**Re: Objection to the Proposed Tirawley Wind Farm Strategic Infrastructure
Development Objection Submission to An Coimisiún Pleanála**

Re: Planning permission for the construction of Tirawley Windfarm consisting of 16 no. wind turbines, a permanent 110kV substation, 110kV underground cable and grid connection, and ancillary development in the townlands of Ballymurphy, Ballynaleck, Barnhill Lower & Upper, Barroe, Billoos, Carn, Carrickanass, Carrowmore, Castlелacken Demesne, and other townlands in County Mayo.

Case Number: PAX16.324258

Plate 12.1: Full 20 km Extent of the Study Area

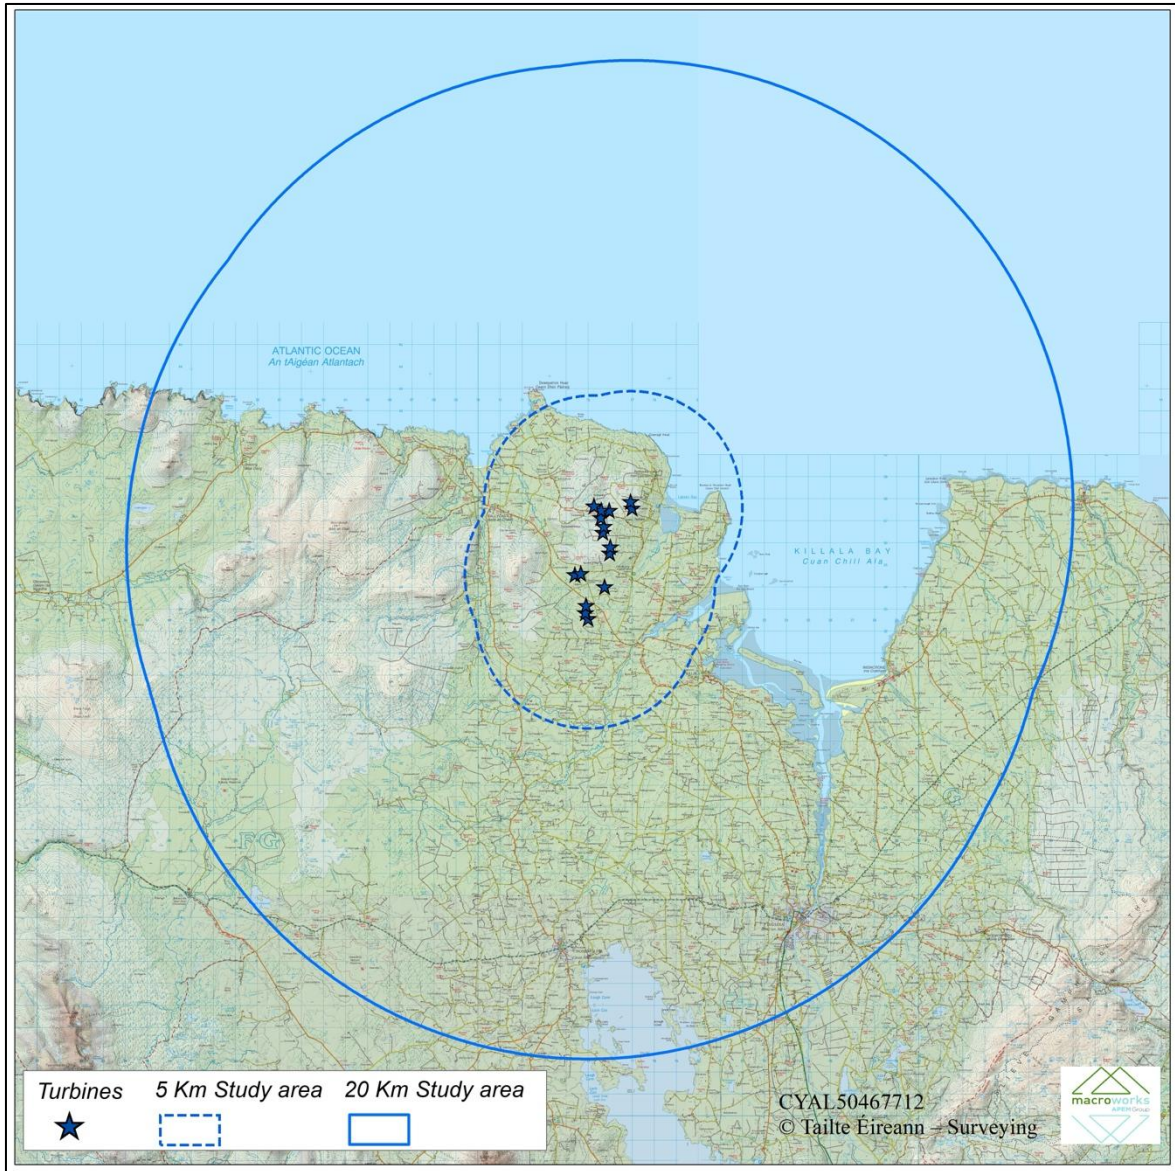
- The 20km (rather than 25km) ZTV study radius is justified by claiming no internationally important landscape exists nearby - directly contradicted by the same chapter's description of the Céide Fields as having 'the oldest known field patterns globally'.

Plate 12.9: Map showing selected representative viewpoints within the study are (Refer to Volume III Figure 12.9 for larger scale version)

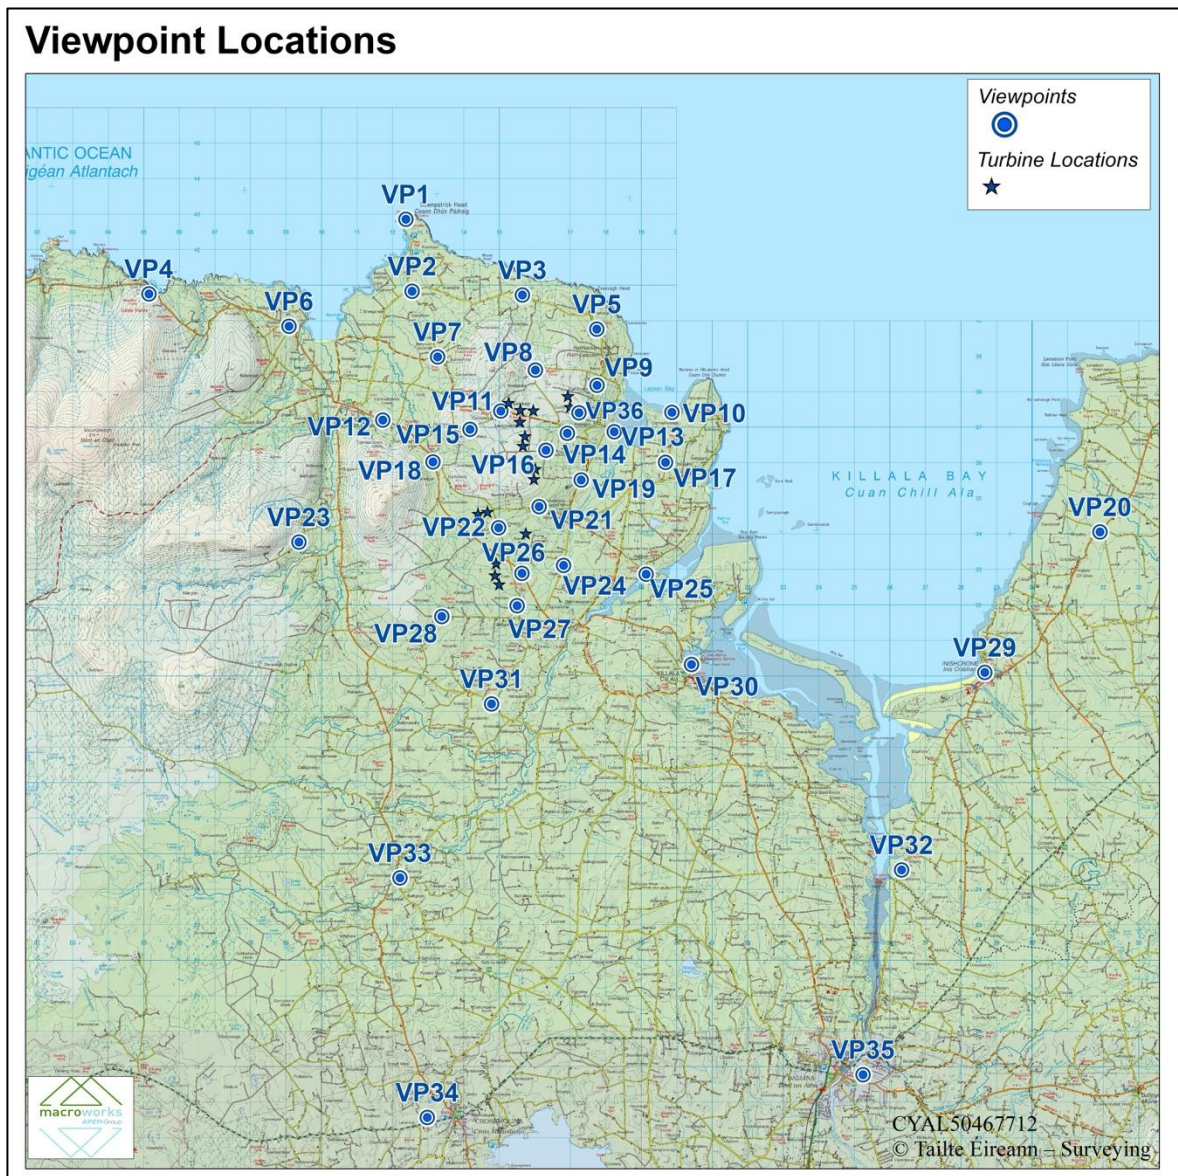
- The Lacken Gazebo (VP36), 300m from AT15/16, is rated 'Substantial-moderate' - the highest individual rating in the chapter - yet folded into an overall 'Not Significant' conclusion.

- Lacken Hill Cemetery is omitted entirely as a viewpoint, despite cemeteries 15km away being assessed in detail.
- A 'High-medium' cumulative magnitude finding (74.6% of the study area affected once Glenora/Keerglen are added) sits beside a headline conclusion of 'no significant effects'.
